Gatwick Airport Northern Runway Project

The Applicant's Response to the Examining Authority's
Written Questions – Landscape, Townscape and Visual
Resources

Application Document Ref: 10.16

PINS Reference Number: TR020005

DRAWING TITLE
**Longbridge Roundabout
 Sketch Landscape Concept**

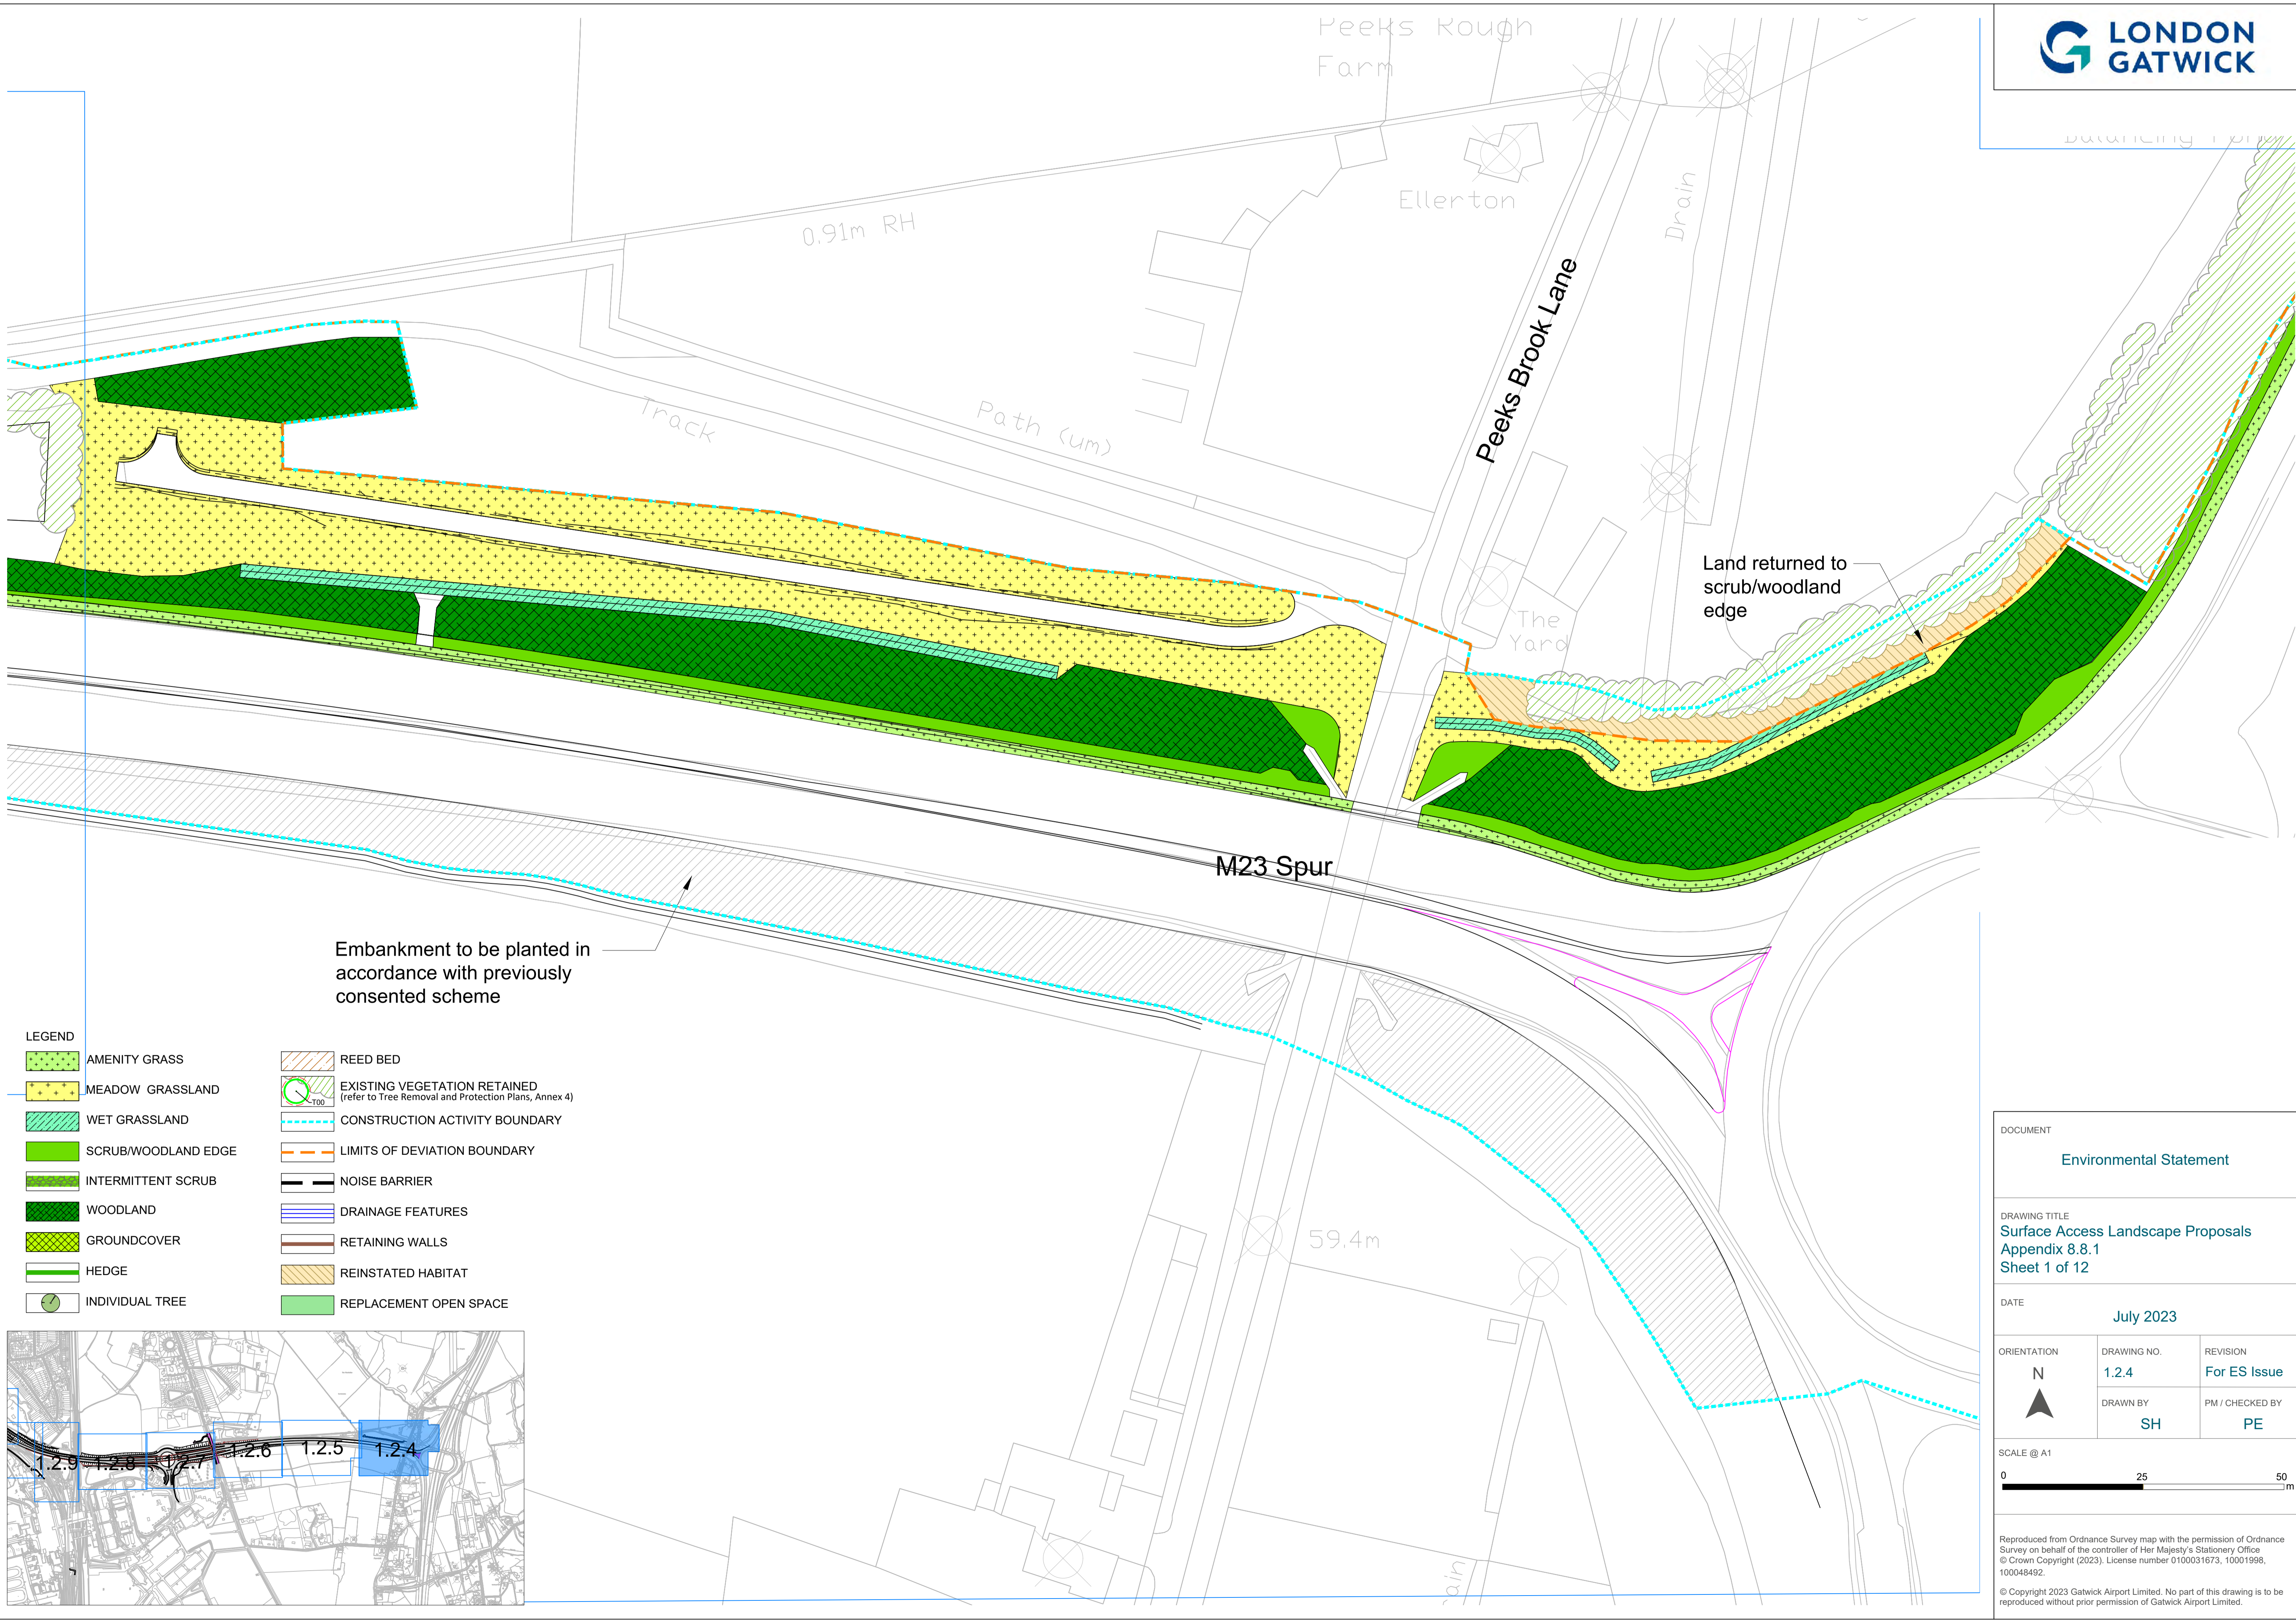
LV.1.4	The Applicant	<p>Living Conditions of Residents</p> <p>Provide an assessment of the visual effects of the Proposed Development upon the living conditions of residents on the residential edges of Horley (including but not limited to those residents of Longbridge Road, Balcombe Road and those identified by the JSCs' LIR [REP1-097]). Such an</p>

<p>assessment to include any effects of lighting and light spill from new proposed structures, such as Car Park Y.</p> <p>Section 8.9 of ES Chapter 8: Landscape, Townscape and Visual Resources [APP-033] includes an assessment of the effects on occupiers of relevant residential properties throughout the construction and operation period, a summary of which is as follows:</p> <p>Gatwick Dairy Farm (a pair of two-storey semi-detached houses with gardens adjacent to the site boundary)</p> <ul style="list-style-type: none"> • 2024 to 2029: Contractors compound and vegetation removal. More open views of existing and temporary lighting and light sources. Moderate to Minor adverse effects during daytime and at night. • 2030 to 2032: Contractors compound and surface access construction activities. More open views of existing and temporary lighting and light sources. Moderate to Minor adverse effects during daytime and at night. • 2033 to 2038: Newly operational surface access improvements and environmental mitigation area. More open views of existing and proposed lighting and light sources. Moderate to Minor adverse effects during daytime and at night. • 2038 and beyond: Mature environmental mitigation area and surface access improvements. Slightly more open views of existing and proposed lighting and light sources.. Minor adverse at night in winter and Negligible adverse during the day.

Landscaping principles and sketch concept plans of landscaping proposals are included within the oLEMP [[REP2-021](#), [REP2-023](#), [REP2-025](#), [REP2-027](#)]. In accordance with Requirement 8 of the **dDCO** (Doc Ref. 2.1 v6), the landscape planting proposals will be submitted to CBC for approval as part of the LEMP (in consultation with the relevant authorities).

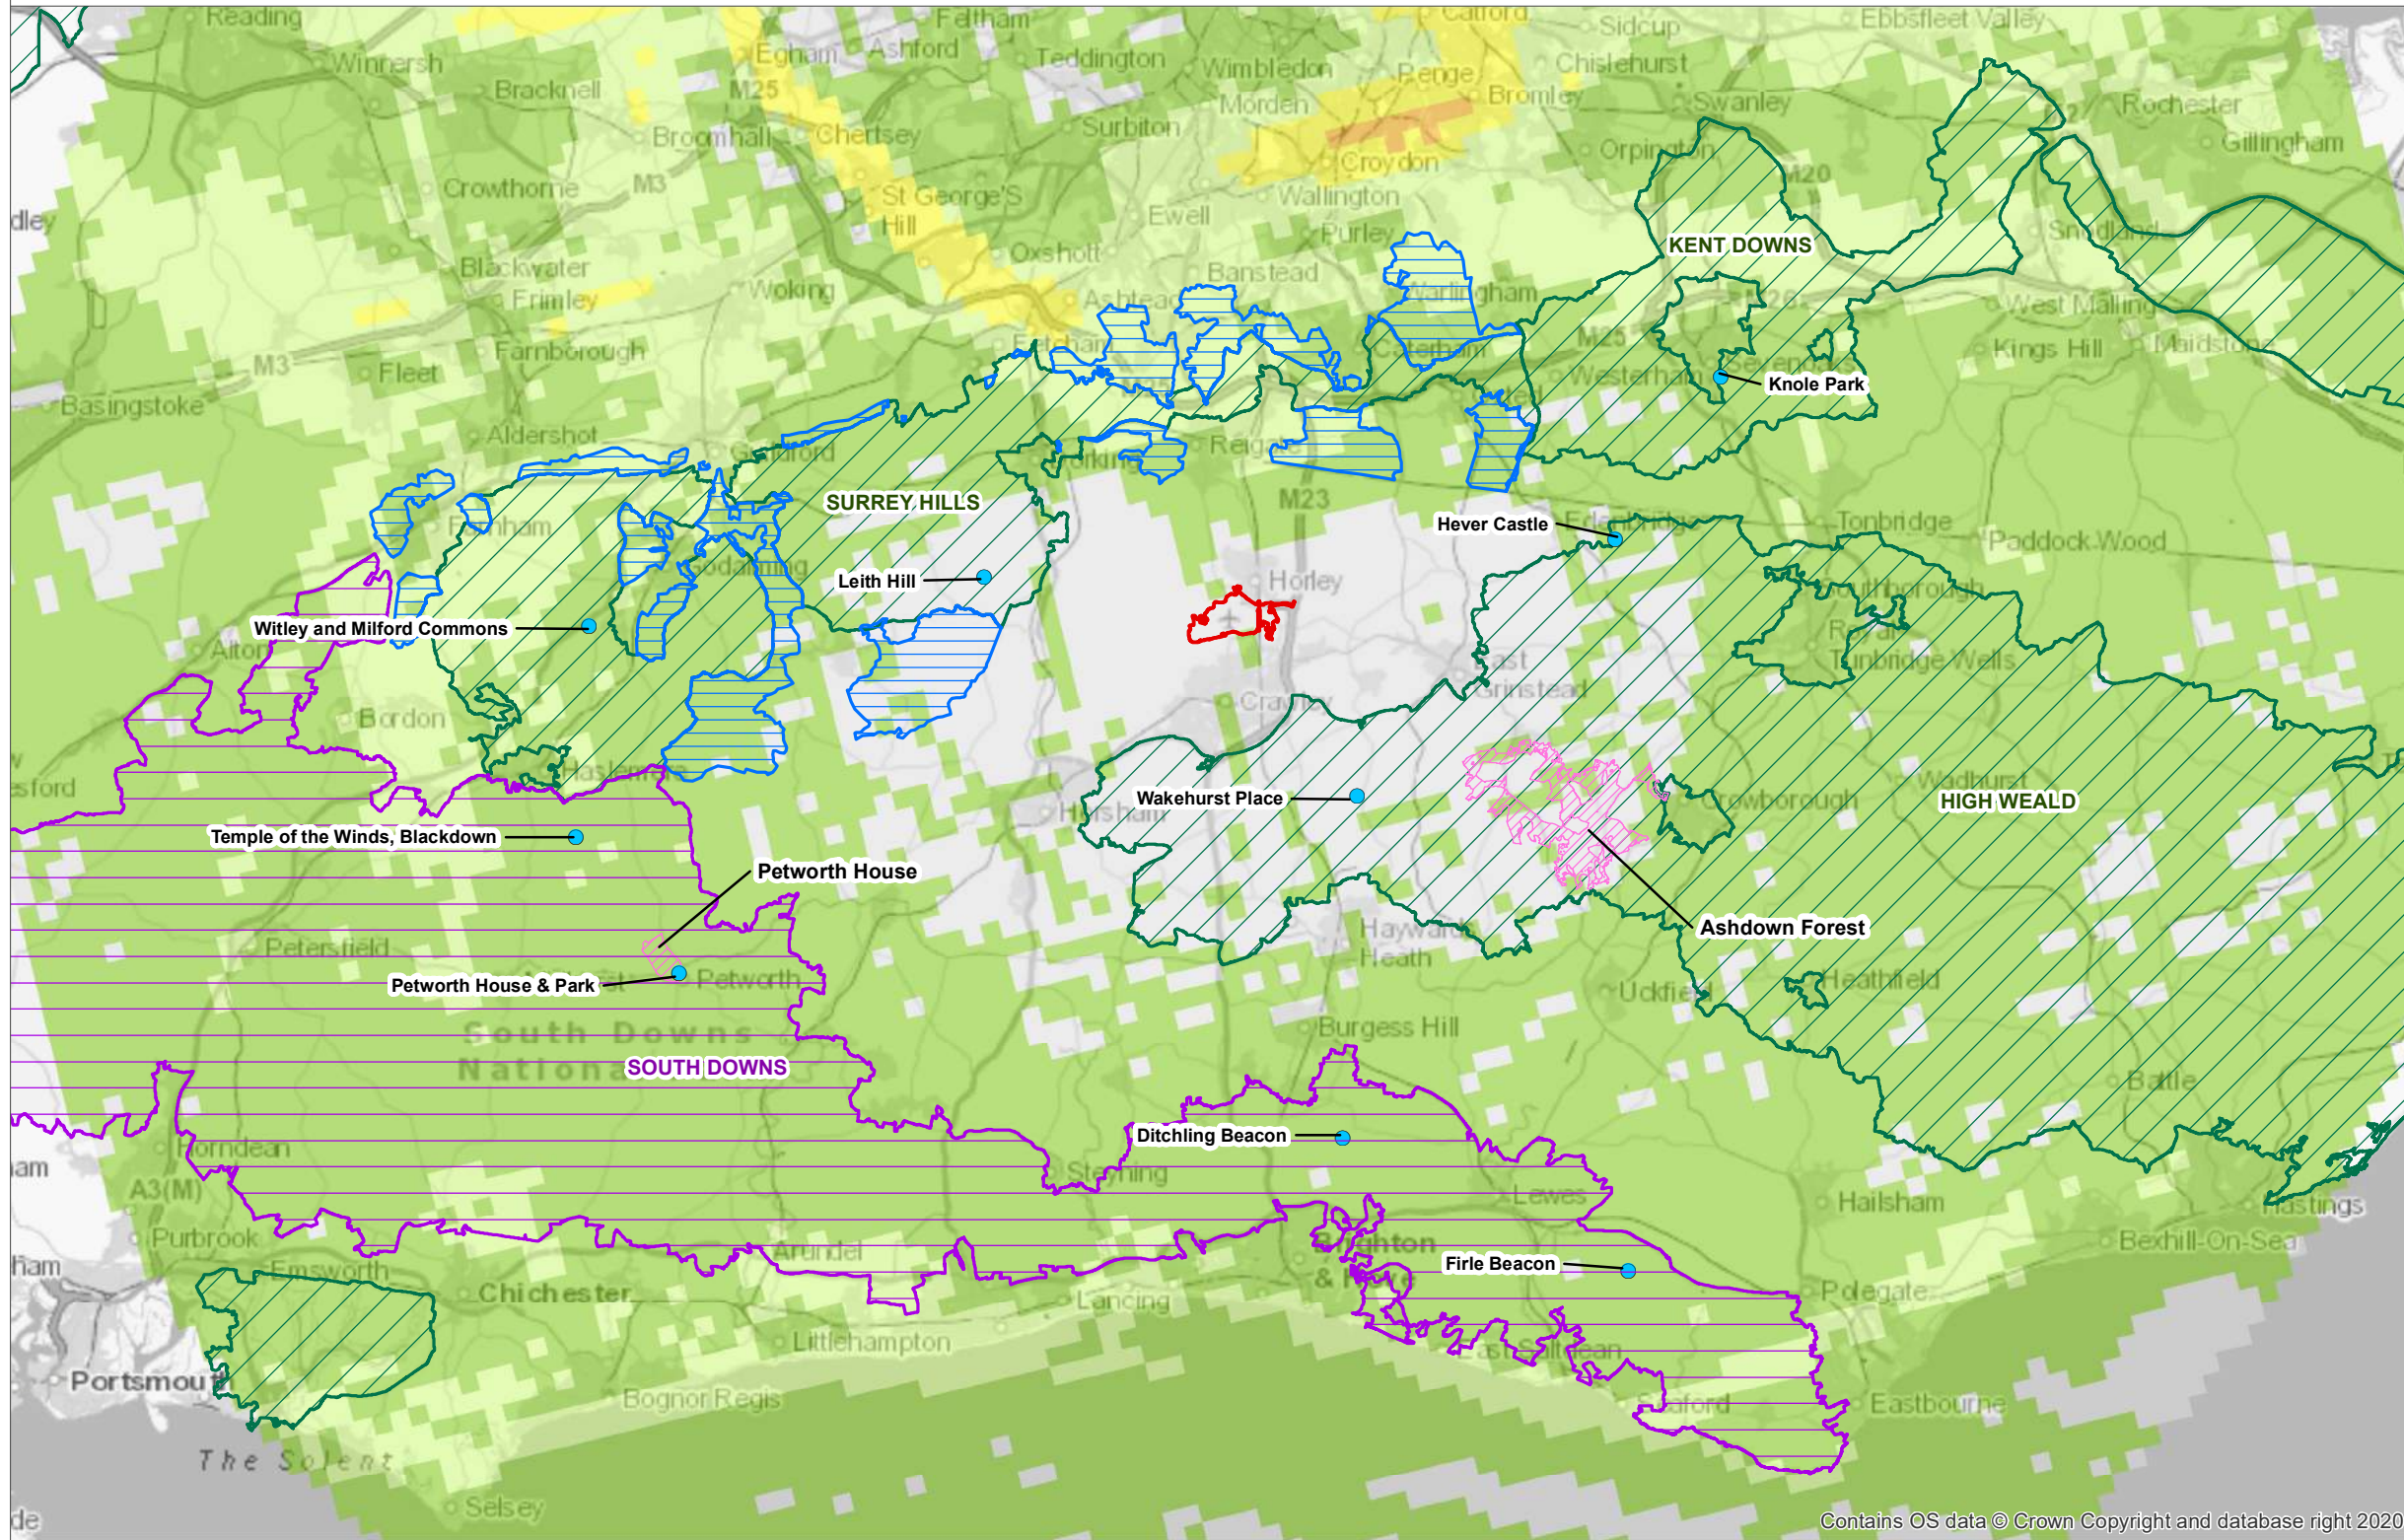
by comparison to the future baseline situation of up to approximately 20% overflights by the end of 2032 and would not exceed this level of increase beyond 2033. **ES Figure 8.6.7 [REP2-007]** shows the increase in the number of Gatwick overflights combined with non-Gatwick overflights in each grid square as a colour. The areas of the landscape currently overflown by the largest number of aircraft would experience the greatest number of additional aircraft. The data within Table 8.9.1 for summary of representative assessment locations and overflight numbers are also relevant to the assessment of effects in 2033 to 2038 and beyond. The level of increase in the number of overflights as a result of the Project by comparison to the future baseline situation at less than 7,000 feet above ground level within the tranquility study area would remain the same as described in detail for the previous period in 2032 as there would not continue to be a significant increase in overflights.
